## Appeal Decision

### Appeal Ref: 6001602

### Old Barn House, High Road, Eastcote HA5 2EW

- The appeal is made under section 78 of the Town and Country Planning Act 1990 (as amended) against a refusal to grant planning permission.
  - The appeal is made by Michael Cowen against the decision of the Council of the London Borough of Hillingdon.
  - The application Ref is 1598/APP/2025/1602.
  - The development proposed is erection of two semi-detached dwellinghouses with associated parking and landscaping.
-

THE OLD BARN HOUSE

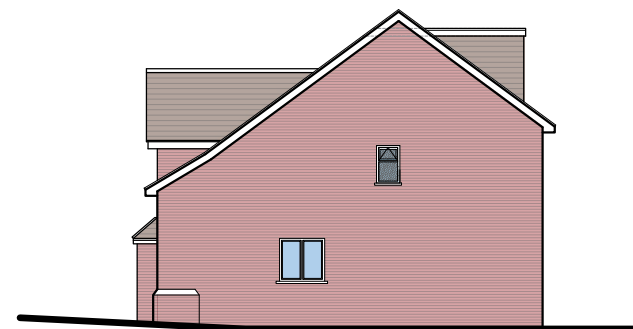
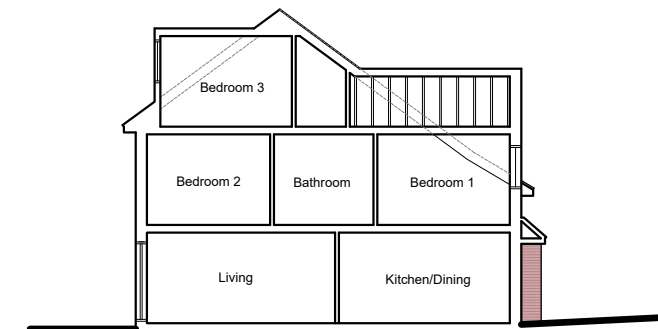
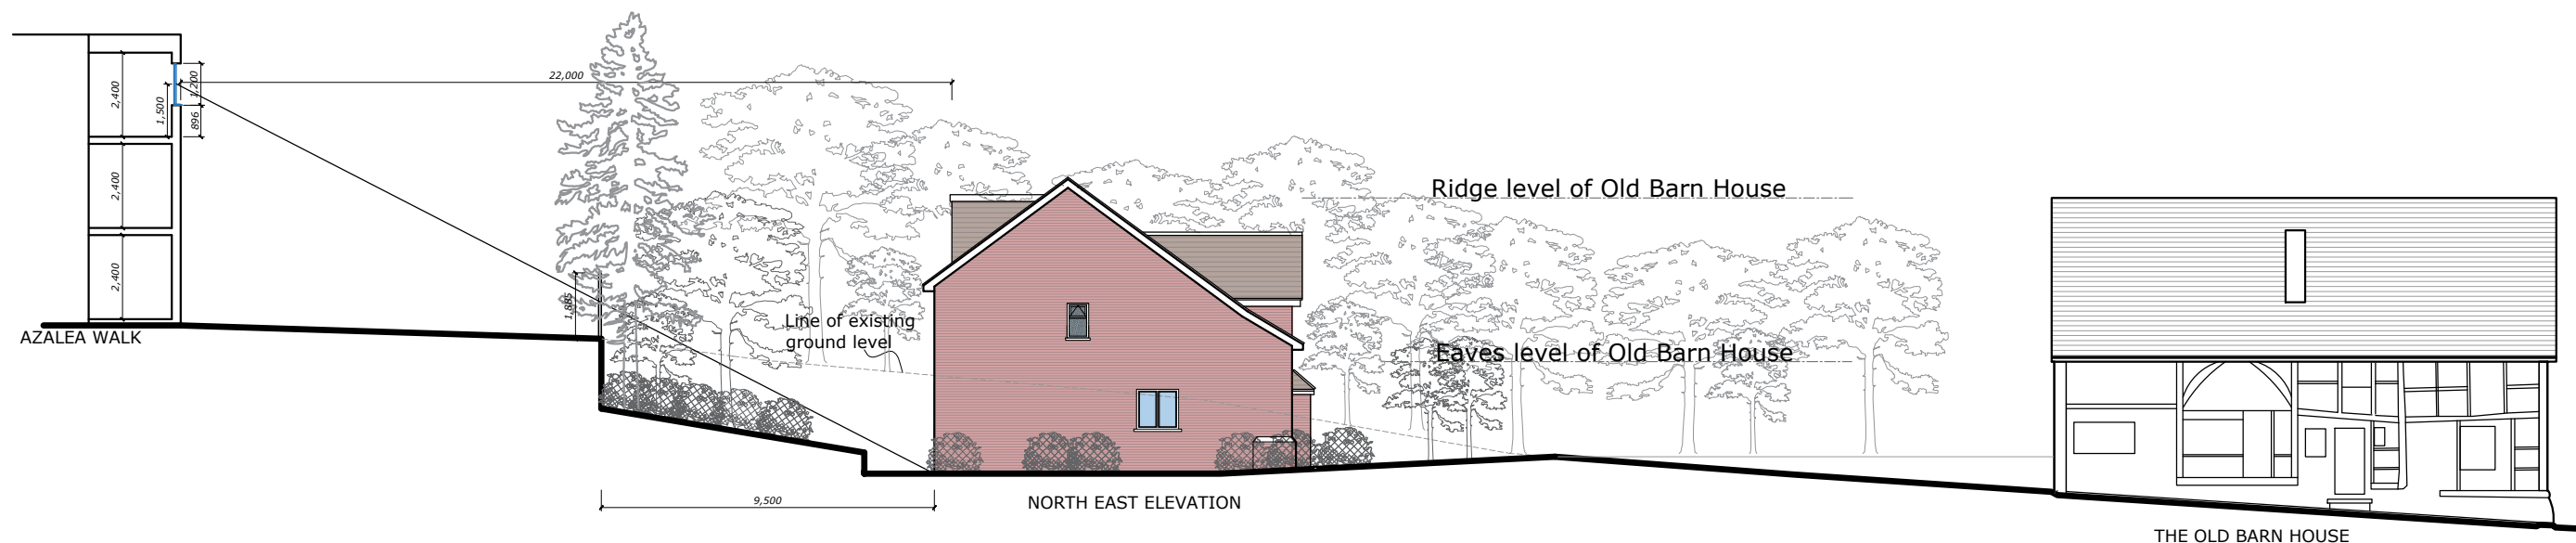
9. The plans show that the proposal would, at its highest, be marginally taller than Old Barn House. Policy DMH6 of the Hillingdon Local Plan Part 2 (2020) (LP2) relates to garden and backland development. The policy, and the explanatory text, set out a presumption against development on garden land, but go on to add that other backland development will be assessed against four criteria. One of these is that development must be more intimate in mass and scale and lower than frontage properties. By being higher than Old Barn House, the development would conflict with this criterion.

EXISTING TREE TO BE REMAINED

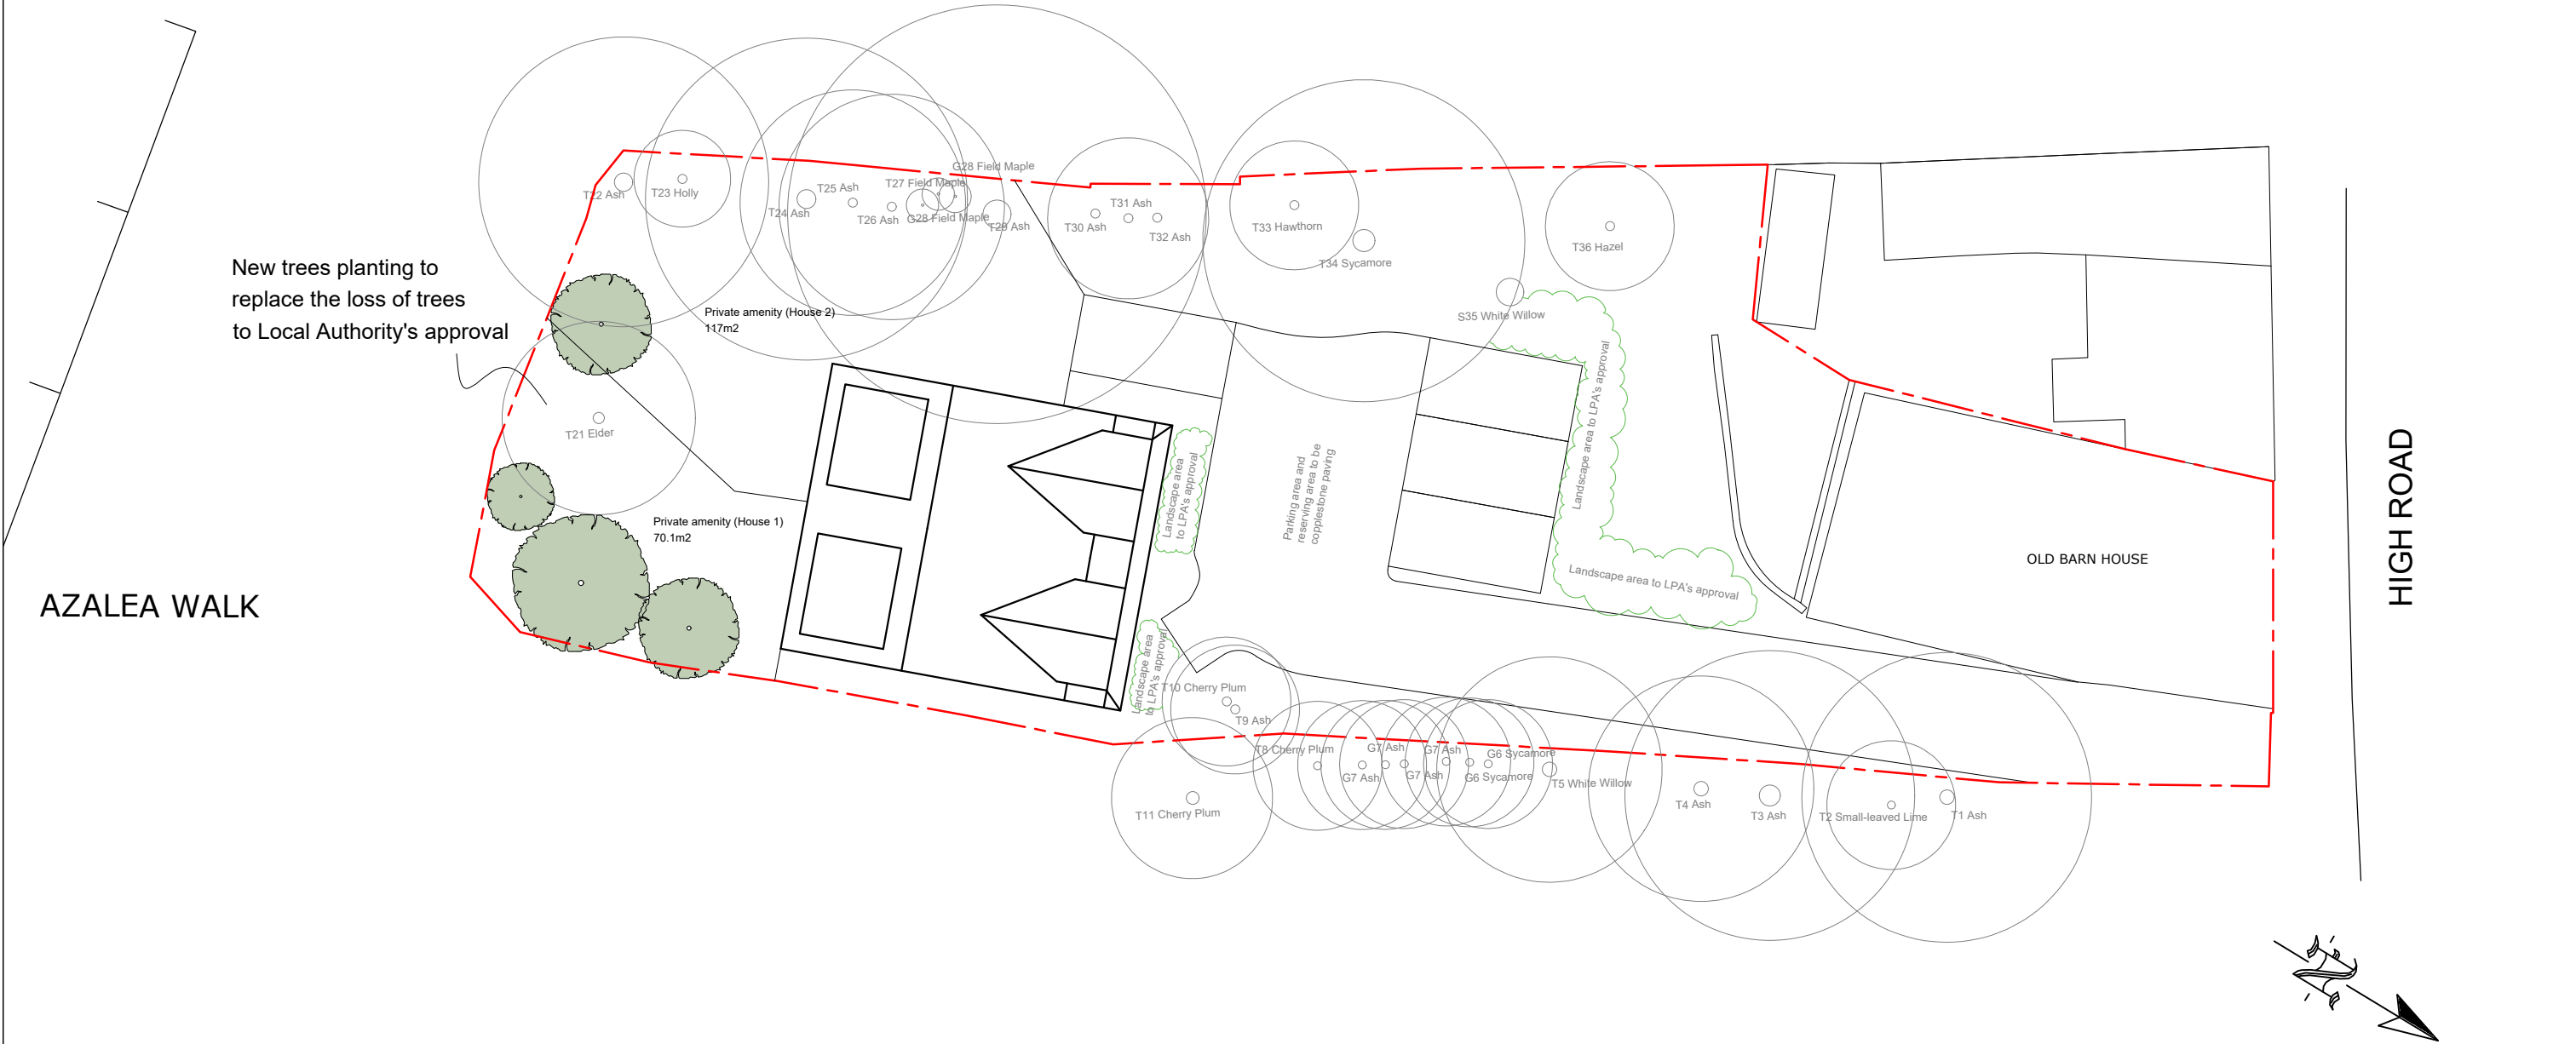
10. With respect to trees, the development would necessitate the removal of nine individual trees and a group of Cherry Plum trees. Five of the individual trees to be removed are identified in the appellant's Arboricultural Impact Assessment (AIA) as being category B2 trees. This means they are of moderate value for mainly landscape qualities. There are no category A trees and nine category B trees on site. Some of the trees to be removed, notably T15, T17 and T18 are at least 10m tall and are visible from High Road and from some positions on Azalea Walk. Indeed, the AIA shows that there are no trees on the site taller than T18. As such, the development would result in the loss of some of the tallest, and most of the best quality, trees on the site.

11. The AIA surveyed 36 trees and groups of trees, of which nine<sup>1</sup> are on adjoining land and one, S35, is only a stump. Nonetheless, the majority of the remaining 26 trees on site would be retained. But these are all along the boundaries of the site, and so the central part of the site would be devoid of trees. The loss of all the trees in this part of the site, and trees that are the tallest on site, would have a significant effect on the verdant character of the area, which contributes strongly to the significance of the EVCA.

12. Four replacement trees are proposed, and shown on the plans. However, one of them is within the canopy of T22 so its growth may be compromised, and the other three, whilst in the corner most bereft of trees, would not adequately mitigate for the loss of five tall and mature category B trees.
